July 14, 2020

**RE: Woodmen Hills Metropolitan District
West Concrete Water Storage Tanks
Site Development Plan (PPR-20-0017) – Comment Response Letter**

**OUTLET STRUCTURE - SECTION B**  
 11x17 SCALE: 3/8"=1'-0"  
 24x36 SCALE: 3/4"=1'-0"

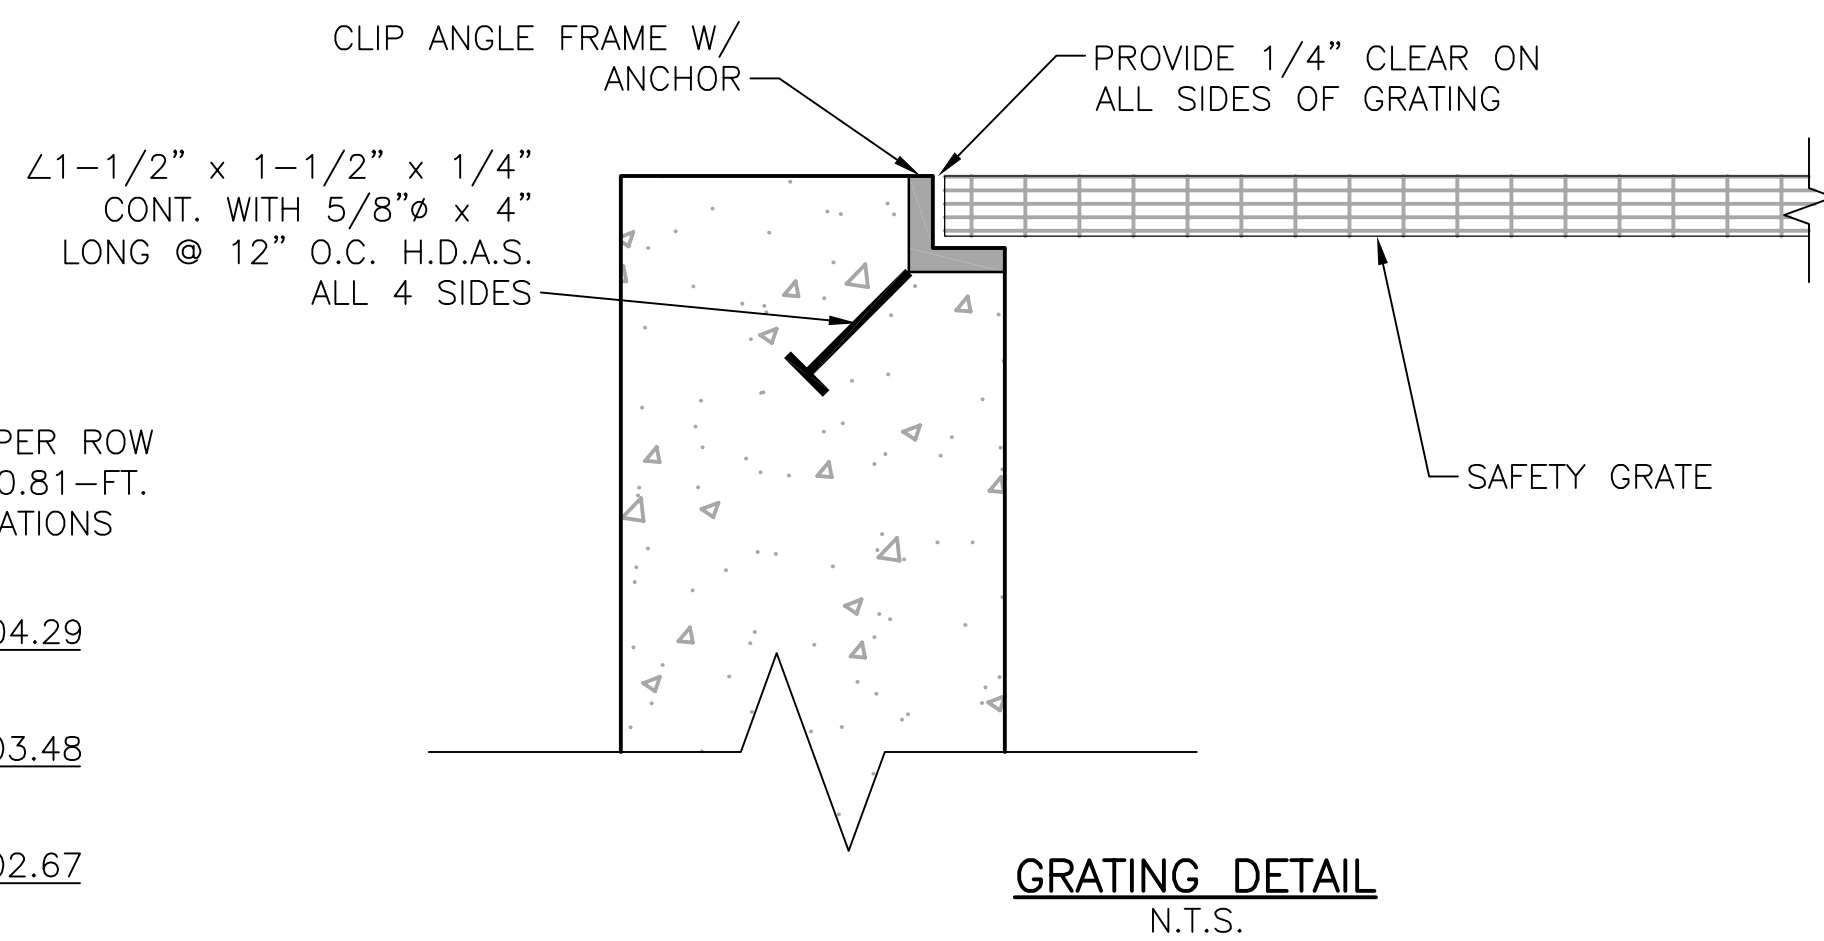
14. Appendix F, DP3: See revision to ECM adopted July 2, 2019. Outlet structure must comply to the details shown in that revision (UDFCD Nov 2015) design.

Outlet structure revised to comply with the details in the UDFCD November 2015 design. Revised drainage sheets are included in Appendix F.

C11
 SHEET 12 OF 30

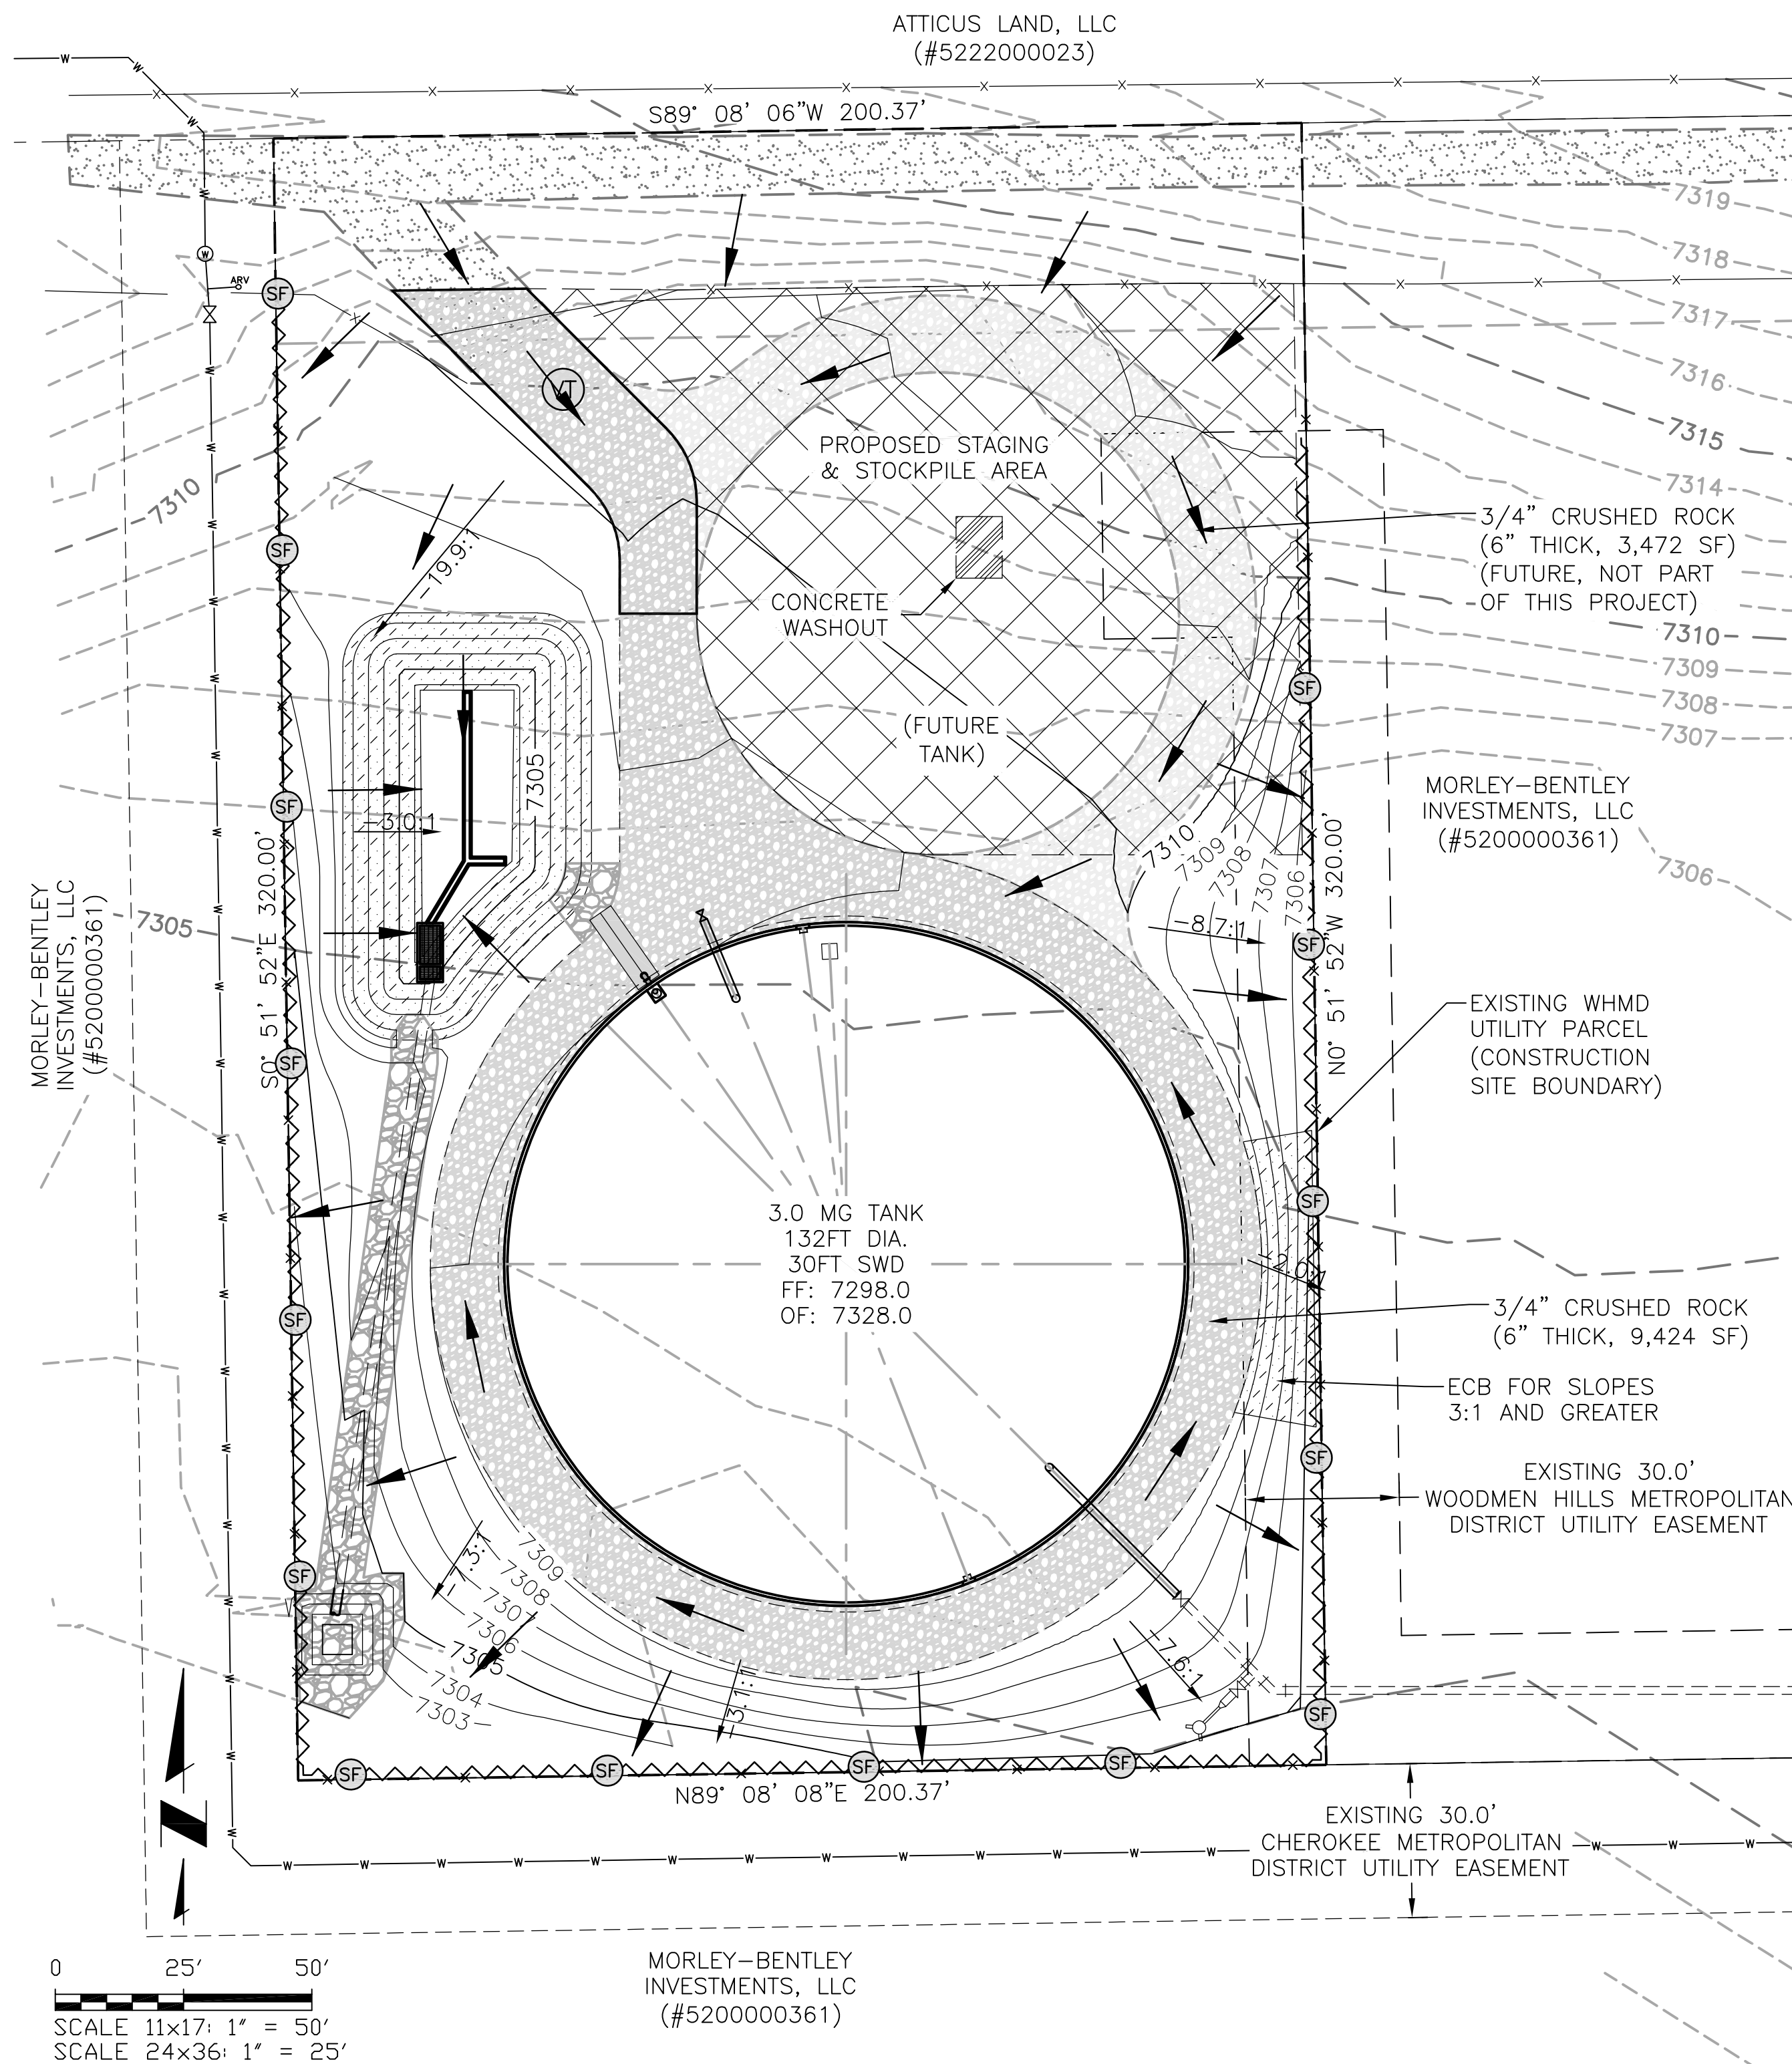
4. Page C11 – show ECB hatching on slopes steeper than 3:1
Addressed in the revised Grading and Erosion Control Plan. Hatching for proposed ECB is shown on slopes steeper than 3:1 which include the slope east of the tank and on the EDB sideslopes.

6. Page C11 – Specify locations for seed and mulch. Will not be seeding over gravel area.
Addressed in the revised Grading and Erosion Control Plan. Note 1 on Sheet C11 was revised as follows, “Seed and mulch all disturbed areas that will not have improvements (i.e. gravel roads, riprap, etc.)”

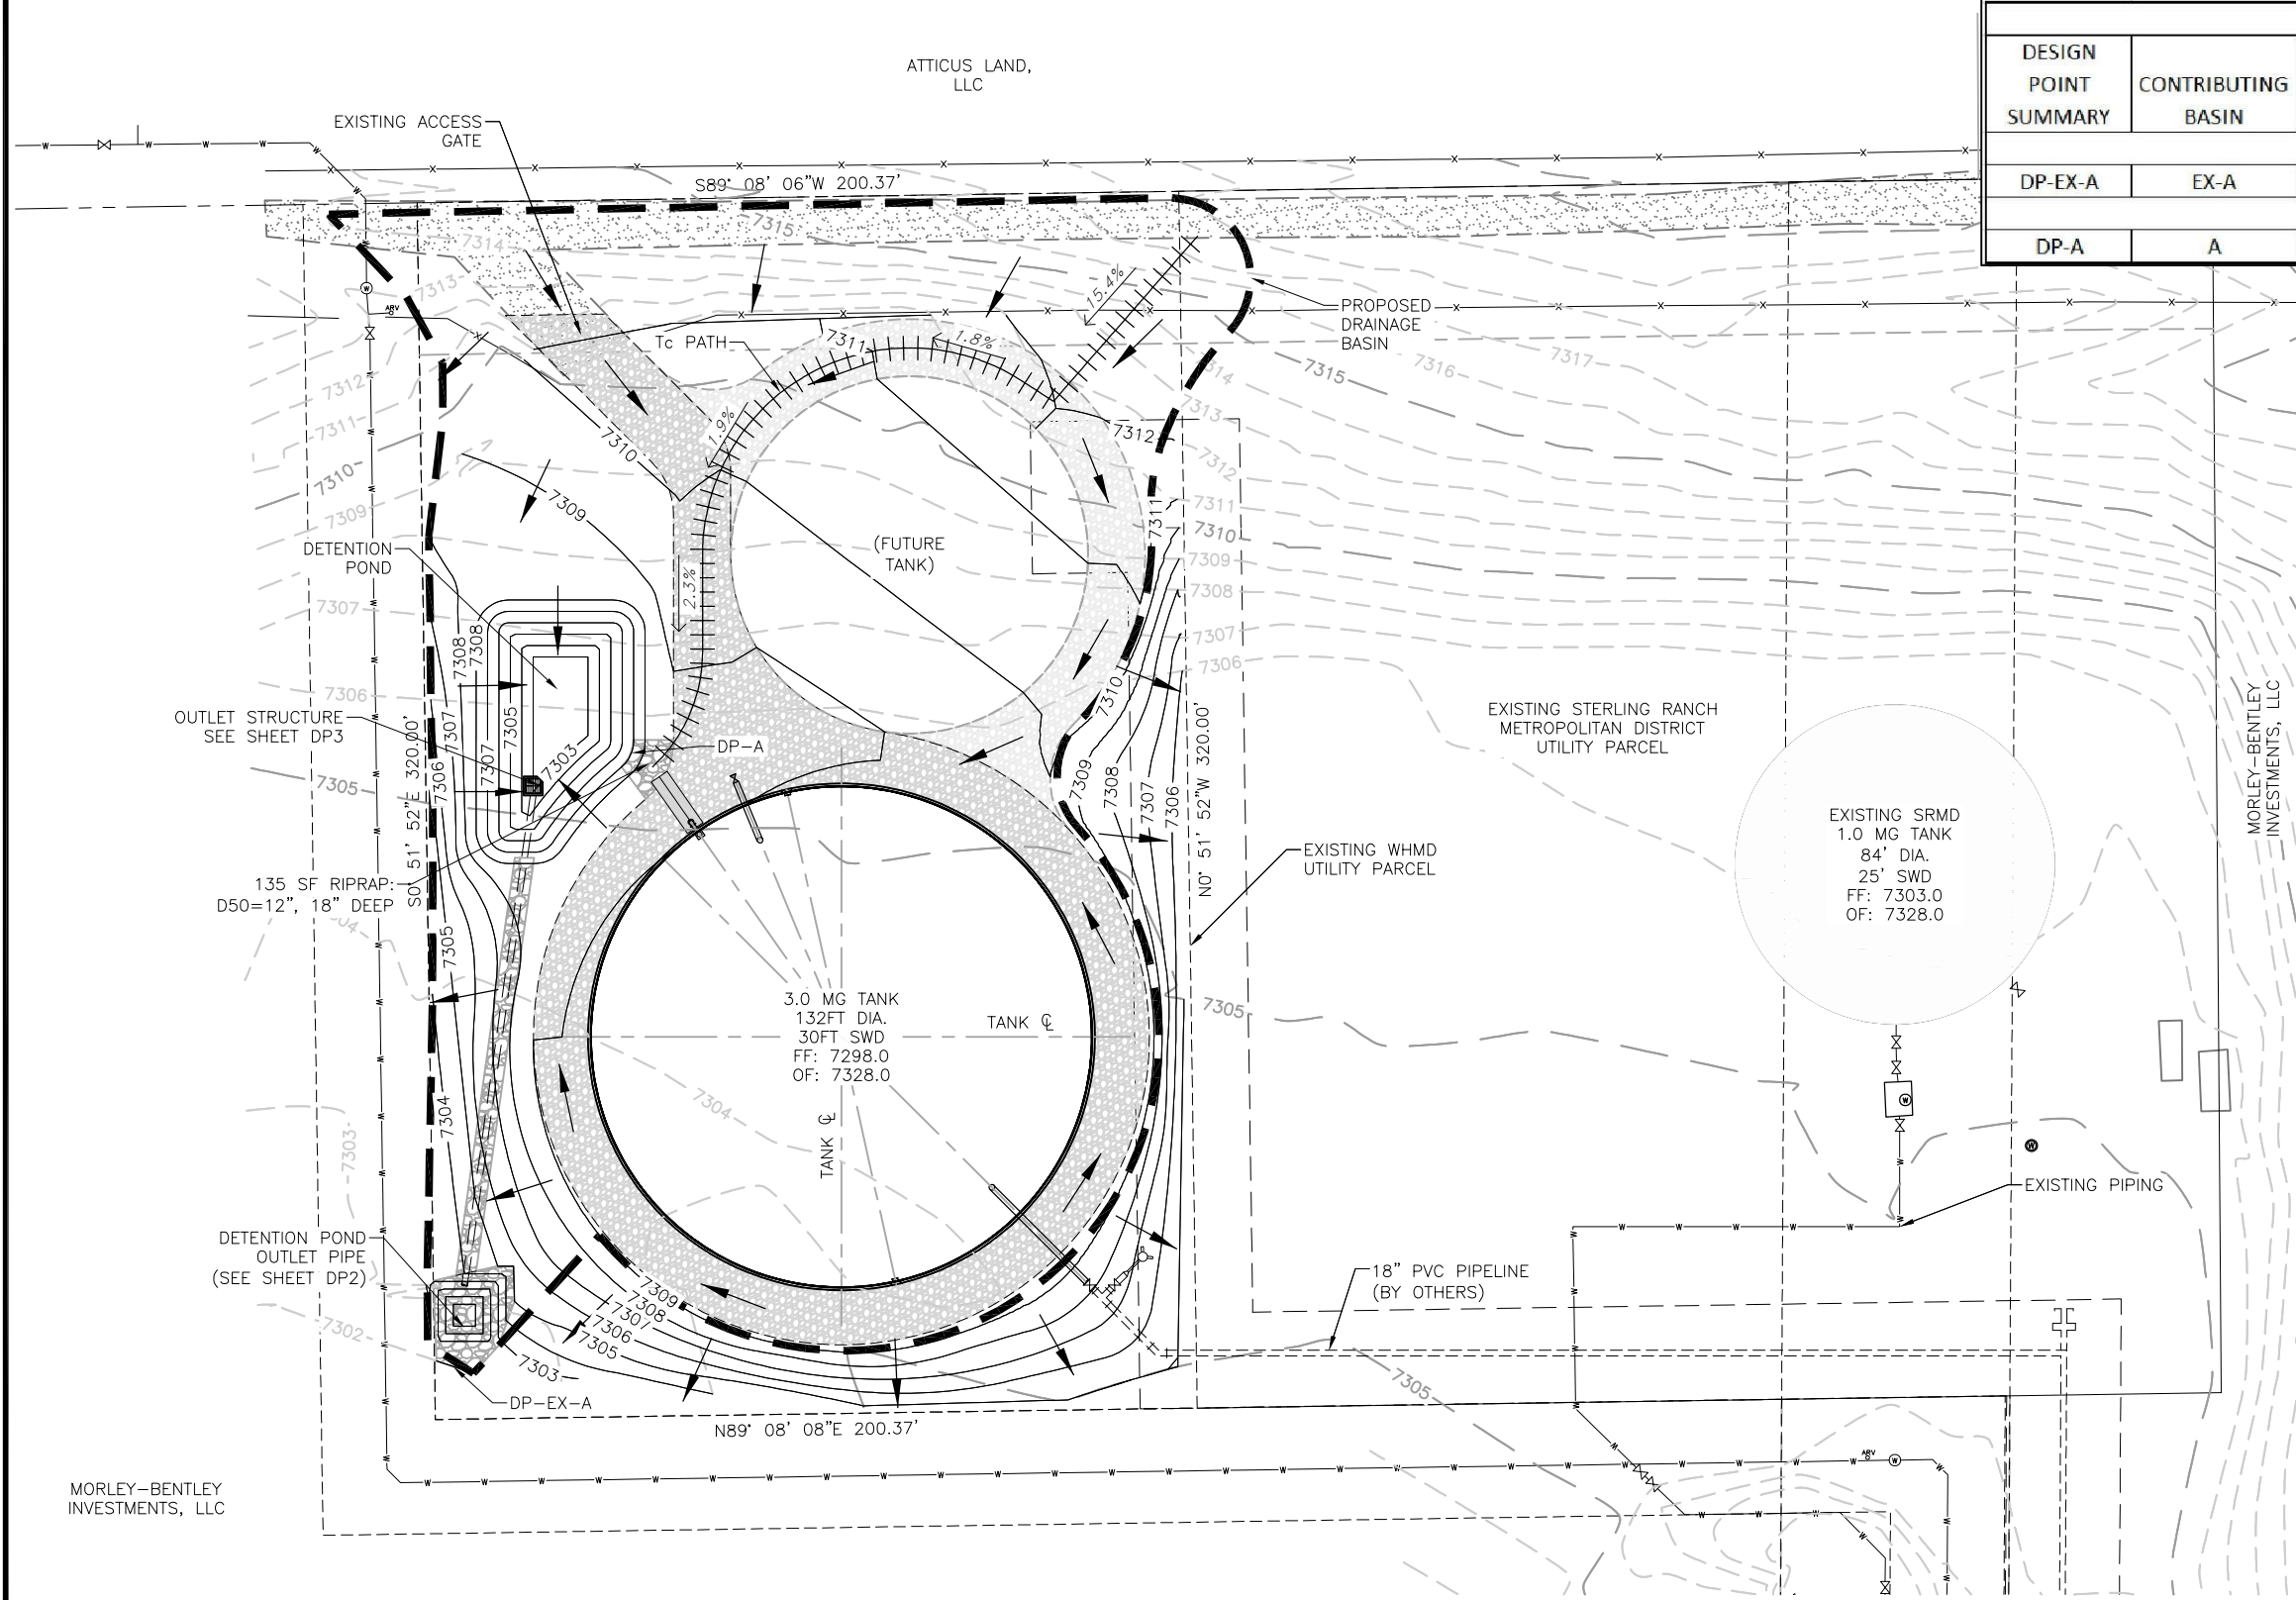
12. Appendix F, DP1: Provide a separate existing conditions Plan/Map. Show all surrounding properties with ownership. The text indicates the outfall goes to Timber Ridge development site.

Addressed in the revised Final Drainage Report.
